**EL PASO COUNTY
 STORMWATER MANAGEMENT PLAN CHECKLIST**

EPC Project Number: MS206

FOREST HEIGHTS CIRCLE GRADING & EROSION CONTROL PLAN
 EROSION CONTROL DETAILS

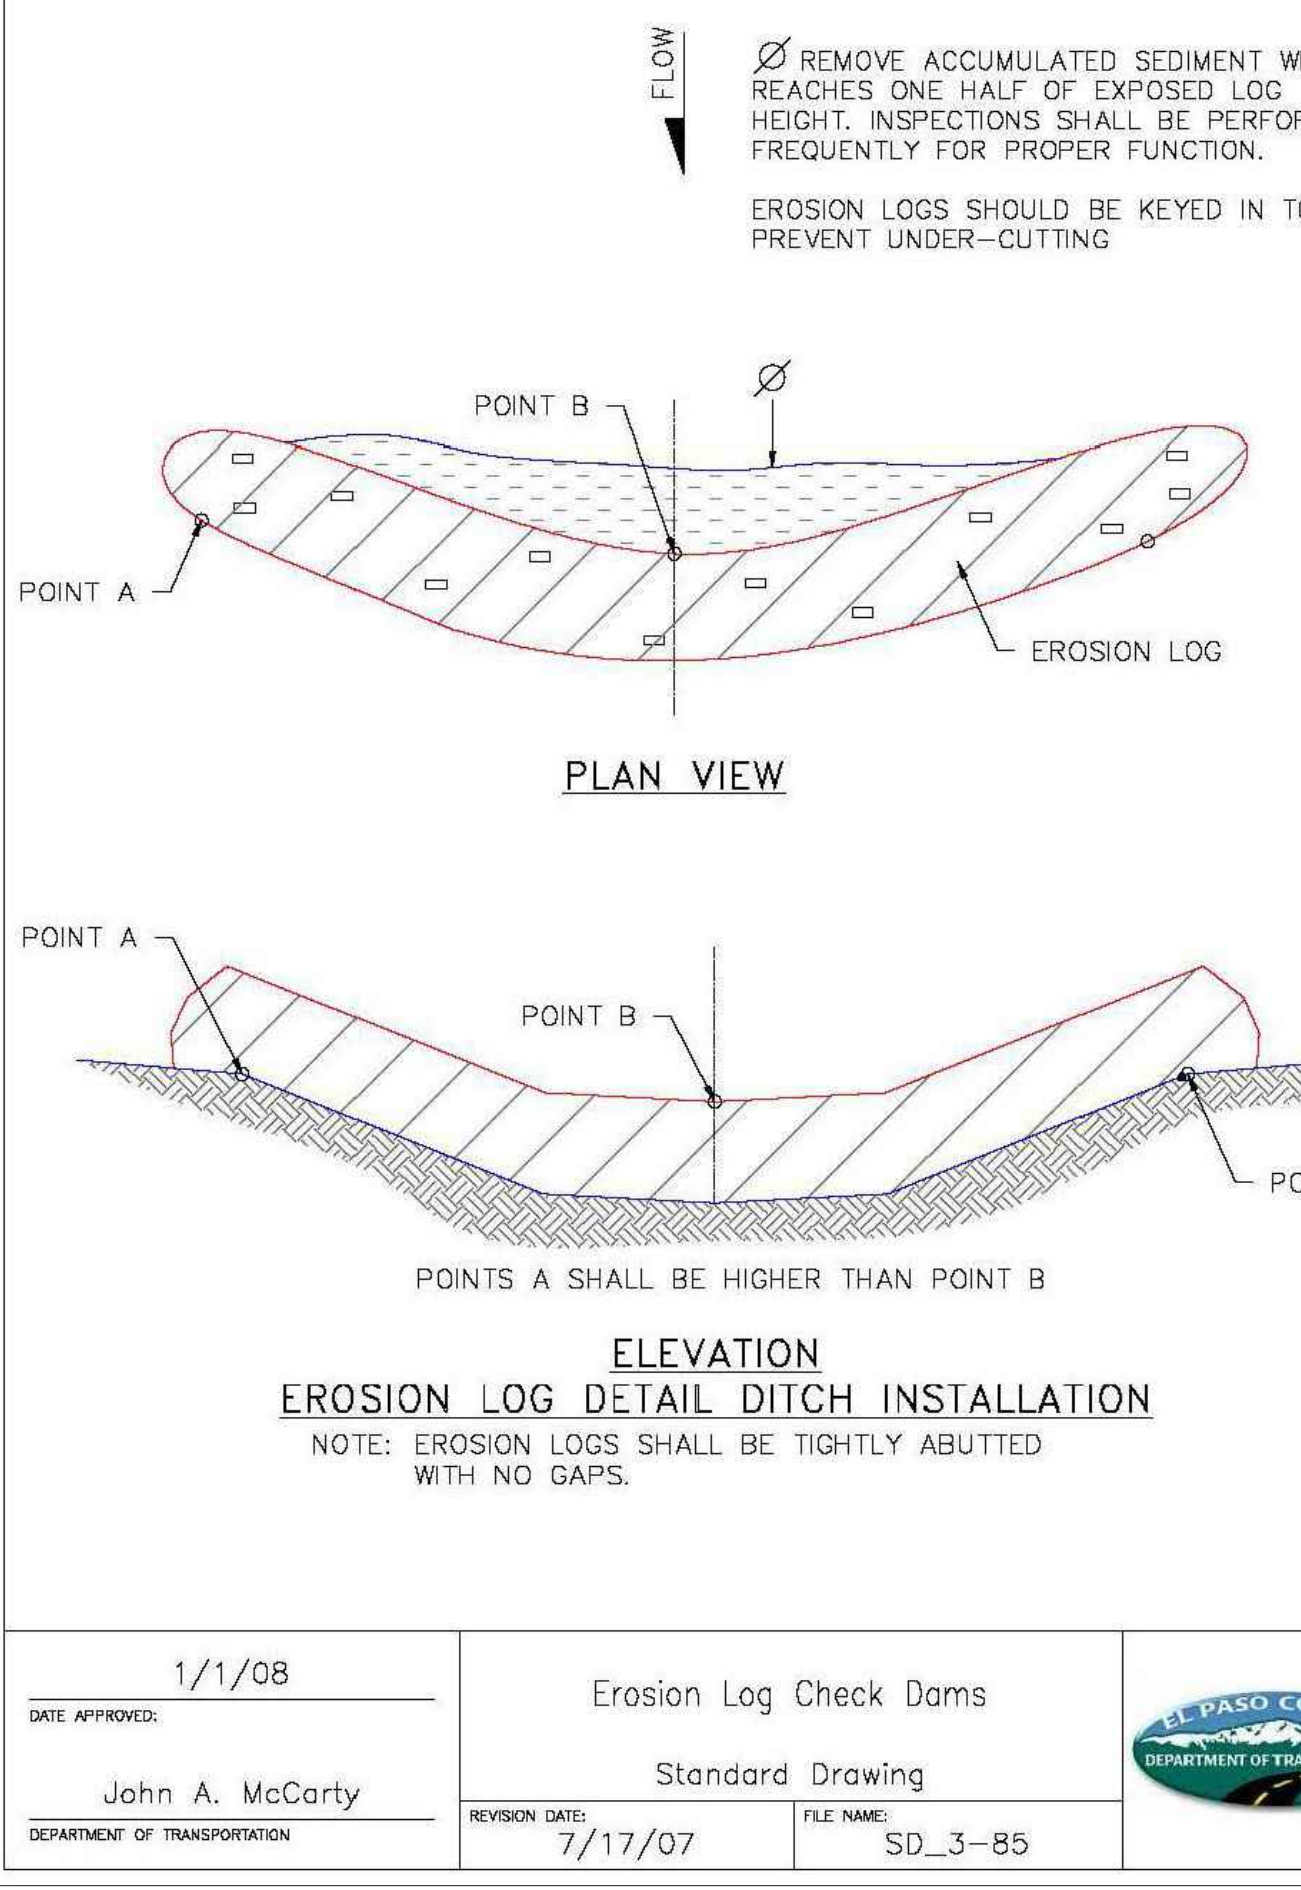
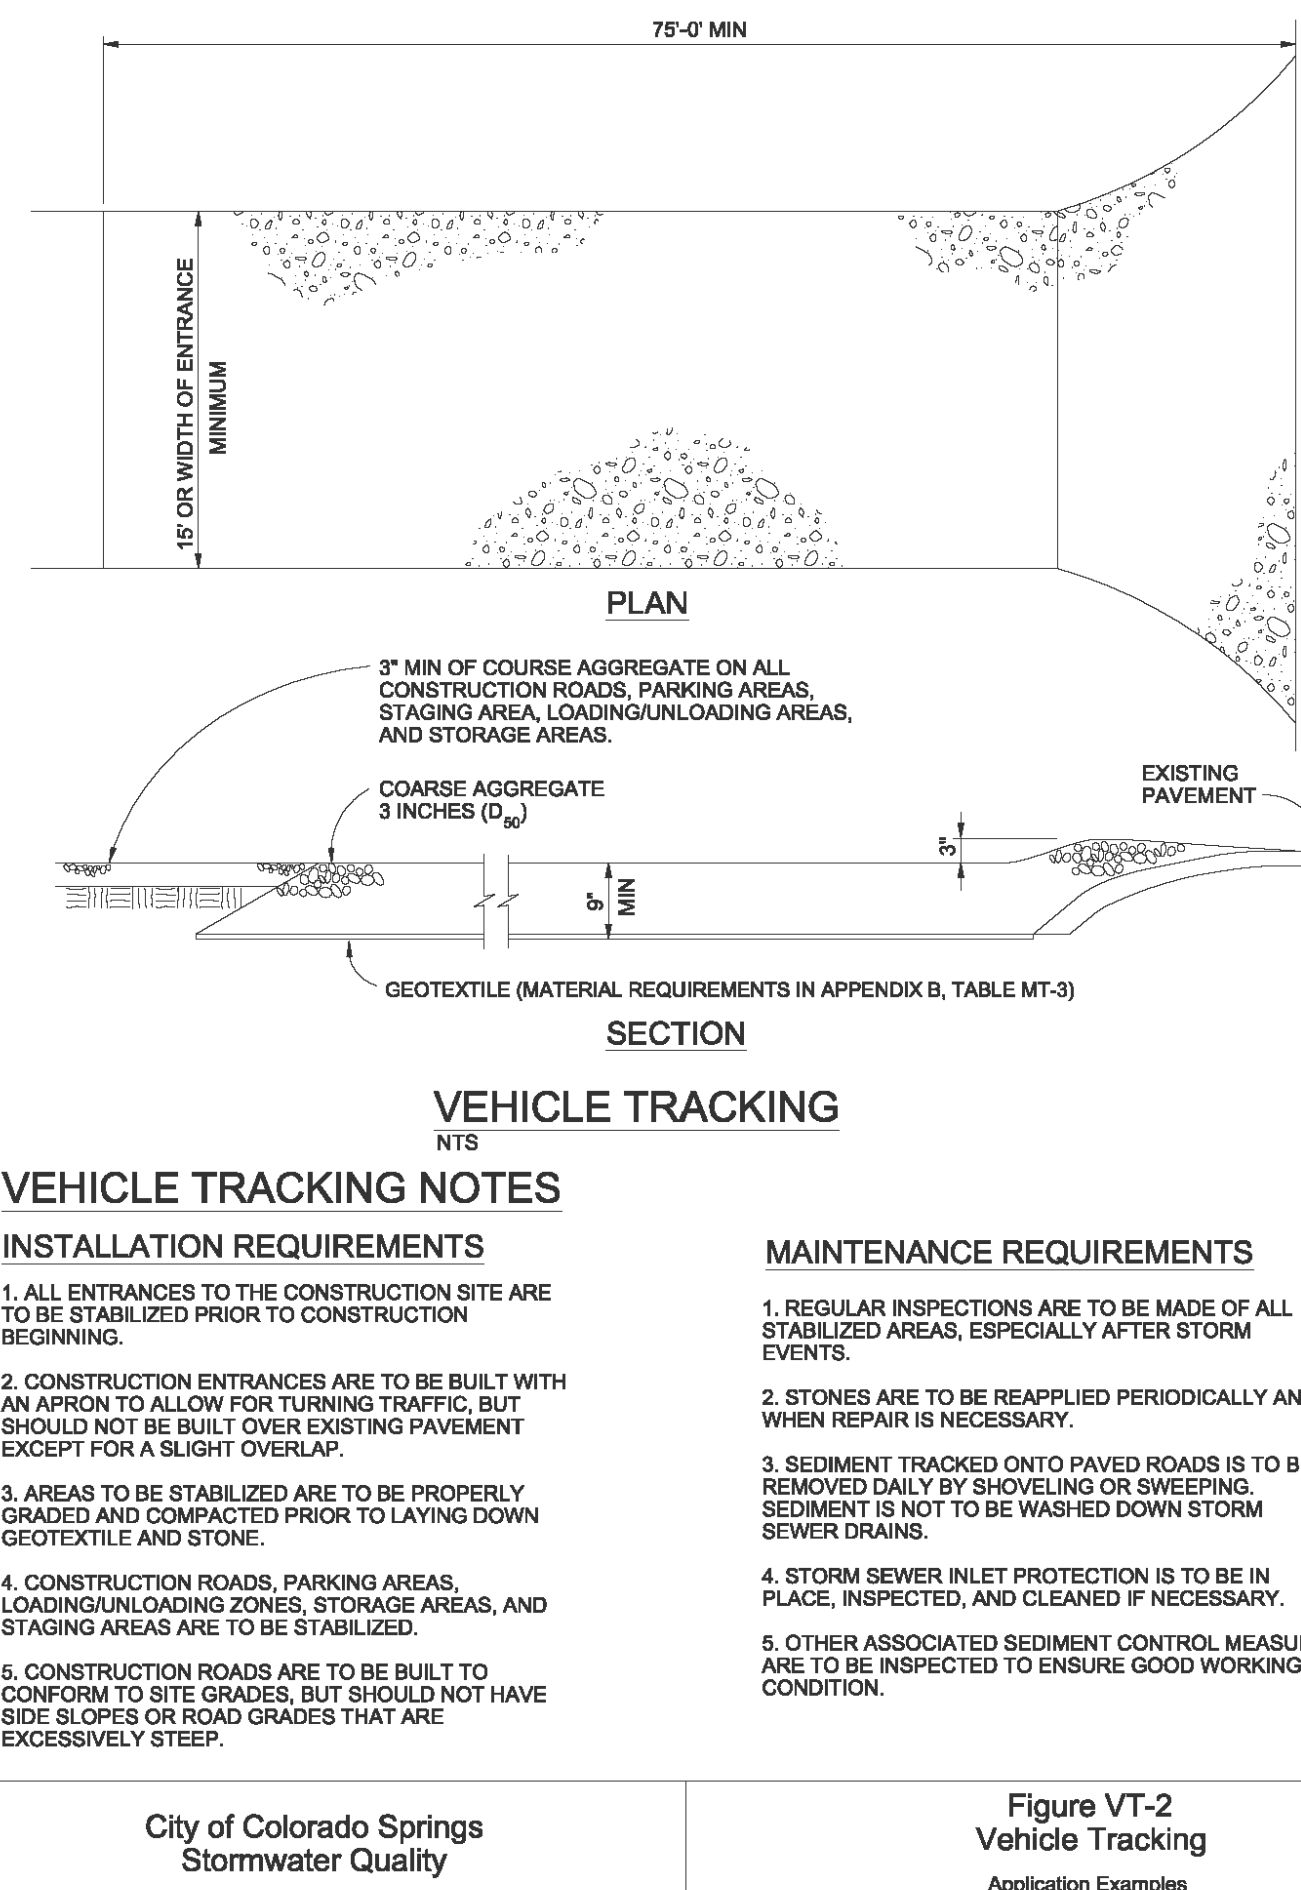
20	Technical drawing details for all control measure installation and maintenance: custom or other jurisdiction's details used must meet or exceed EPC standards Provide a VTC detail	x	N
21	Procedure describing how the SWMP is to be revised	x	Y
22	Description of Final Stabilization and Long-term Stormwater Quality (describe nonstructural and structural measures to control SW pollutants after construction operations have been completed, including detention, water quality control measure etc.)	x	Y
23	Specification that final vegetative cover density is to be 70% of pre-disturbed levels	x	N
24	Outline of permit holder inspection procedures to install, maintain, and effectively operate control measures to manage erosion and sediment	x	Y
25	Record keeping procedures identified to include signature on inspection logs and location of SWMP records on-site	x	Y
26	If this project relies on control measures owned or operated by another entity, a documented agreement must be included in the SWMP that identifies location, installation and design specifications, and maintenance requirements and responsibility of the control measure(s)	x	Y
